Ribble Valley Borough Council
Development Control
Council Offices Church Walk
Clitheroe
Lancashire
BB7 2RA

Our ref: NO/2012/103478/02-L01
Your ref: 3/2012/0179
Date: 21 September 2012

**OUTLINE APPLICATION FOR A RESIDENTIAL DEVELOPMENT FOR THE
ELDERLY, COMPRISING OF 38 BUNGALOWS AND 40 RETIREMENT
APARTMENTS
LAND AT ACCRINGTON ROAD, WHALLEY, CLITHEROE**

2.2. Design Strategy - Indicative Site Layout

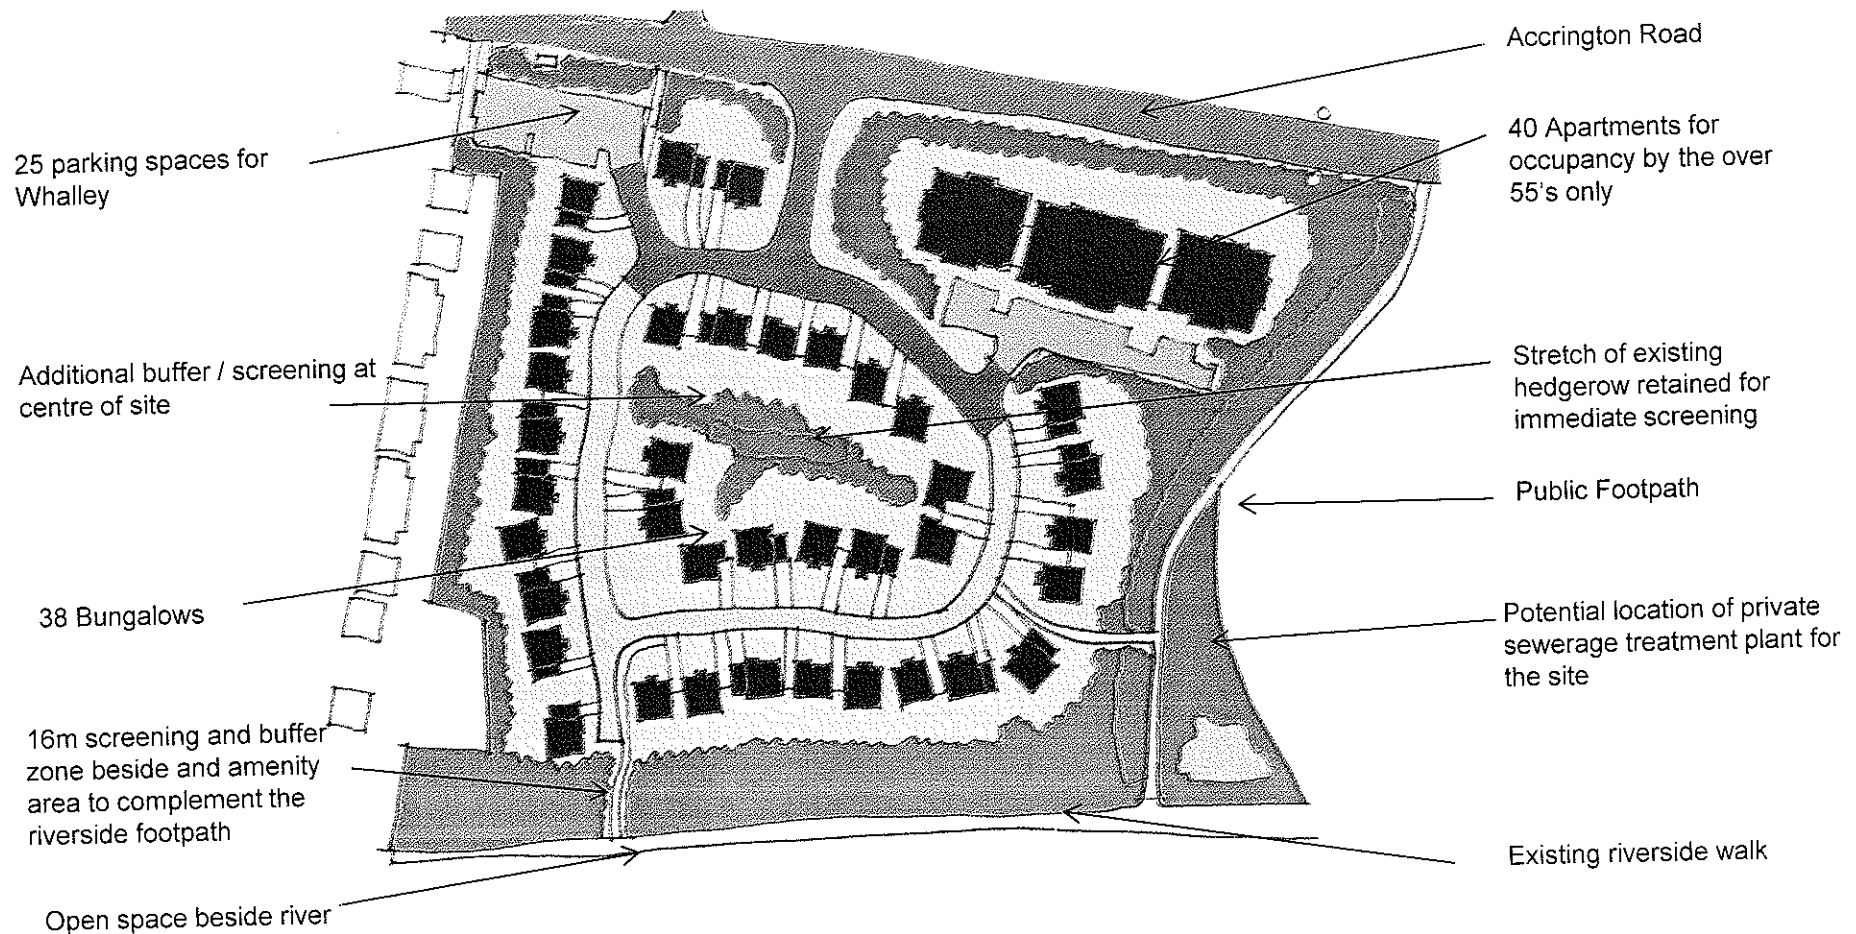
The illustrative layout plan also features a possible wildlife pond. While we would support the creation of a wildlife pond in principle, further details would be required in relation to the proposed location, landscaping and management.

CONDITION No development shall take place until the proposed wildlife pond as shown on the revised illustrative site layout (dwg. no. 1637-40 H) is constructed in accordance with a scheme to be submitted to and approved in writing by the local planning authority.

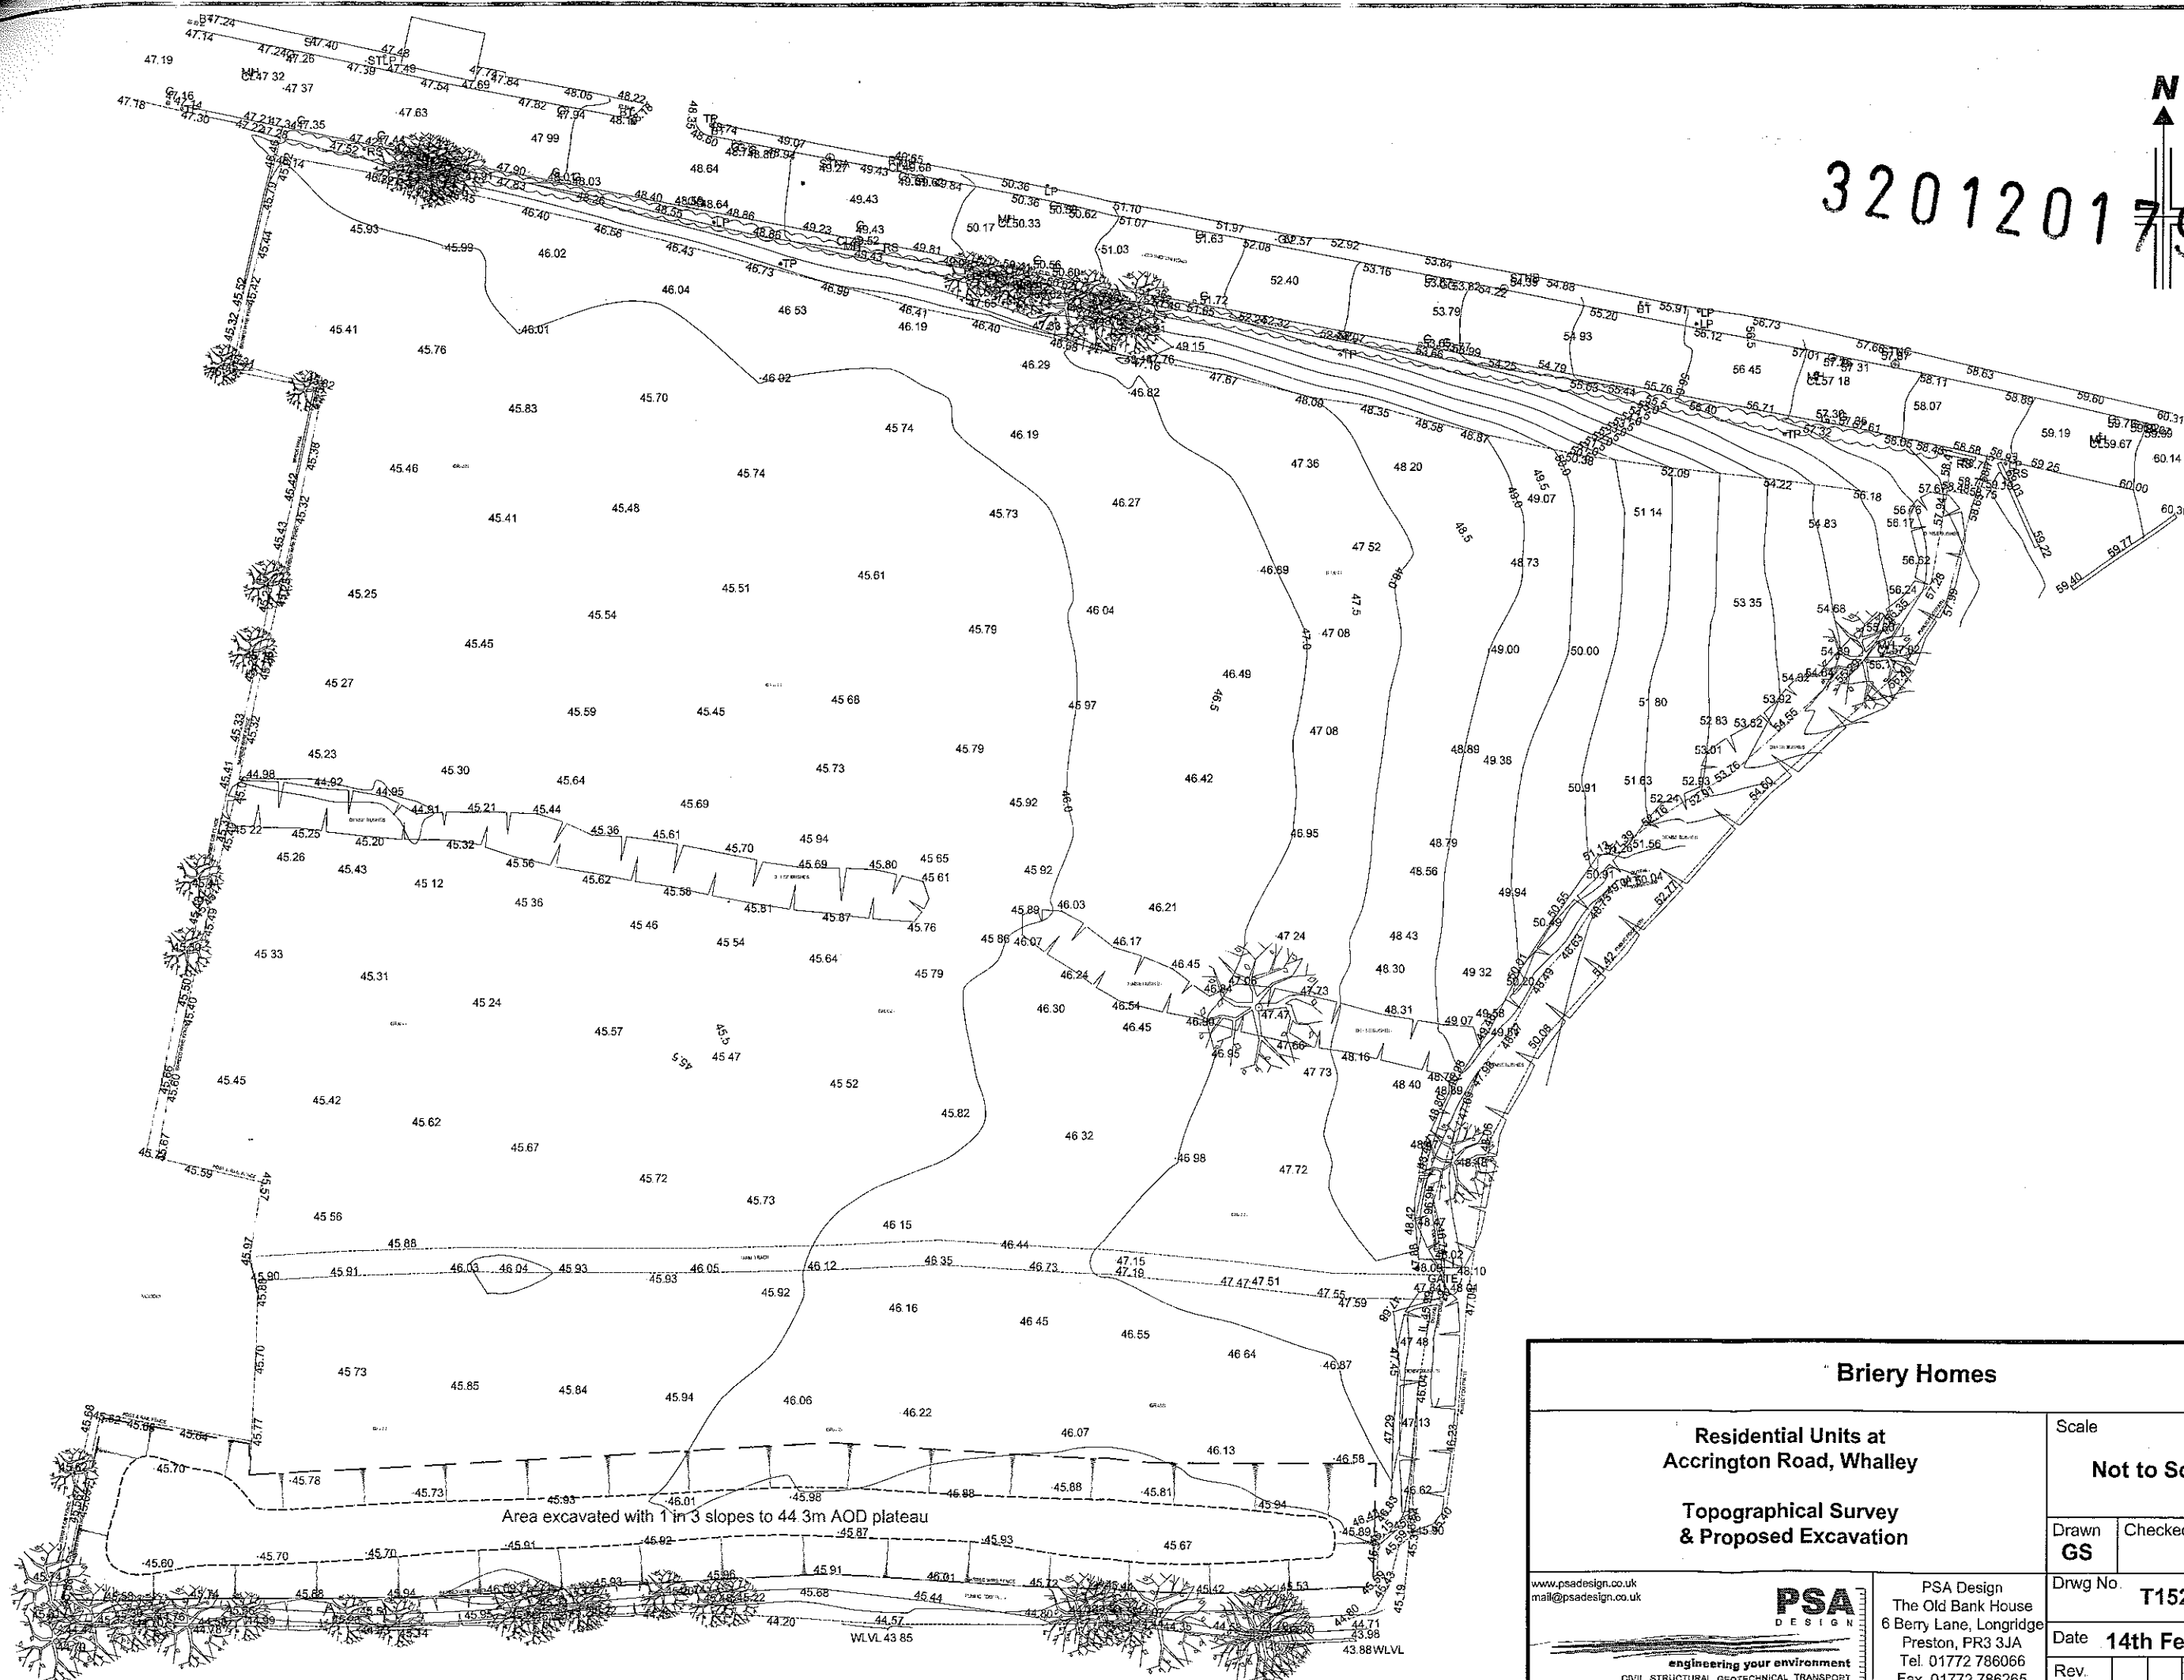
The proposed flood compensation scheme will ensure that the proposed development will not be at an unacceptable risk of fluvial flooding or exacerbate fluvial flood risk elsewhere provided that the Flood Compensation Scheme dated 24 August 2012 submitted with this application is implemented and the recommended measures outlined within it are secured by way of planning conditions on any planning permission.

CONDITION The flood compensation scheme outlined in the report dated 24 August 2012 and referenced SMB/557/2383 by Herrington Consulting shall be constructed and completed in full to the satisfaction of the local planning authority prior to the commencement of any other development on site

CONDITION All ground floor levels shall be set at 46.60 metres above Ordnance Datum (AOD).

It is noted that this is an Outline application with all matters reserved apart from access. While the proposed site layout is illustrative, any subsequent Reserved Matters application for appearance, landscaping, layout and scale should be in accordance with the agreed flood storage measures outlined in the report by Herrington Consulting.

It is essential that the flood storage area is not developed and remains free from obstructions. To this effect, we would also recommend permitted development rights are removed as part of any subsequent approval.

CONDITION Notwithstanding the provisions of the Town and Country Planning (General Permitted Development) Order 1995 or any order revoking and re-enacting that Order with or without modification, no structure shall be erected within the flood storage area as delineated within the letter report by Herrington Consulting dated 24 August 2012; reference SMB/557/2383 and the revised illustrative site layout (dwg. no. 1637-40 H)
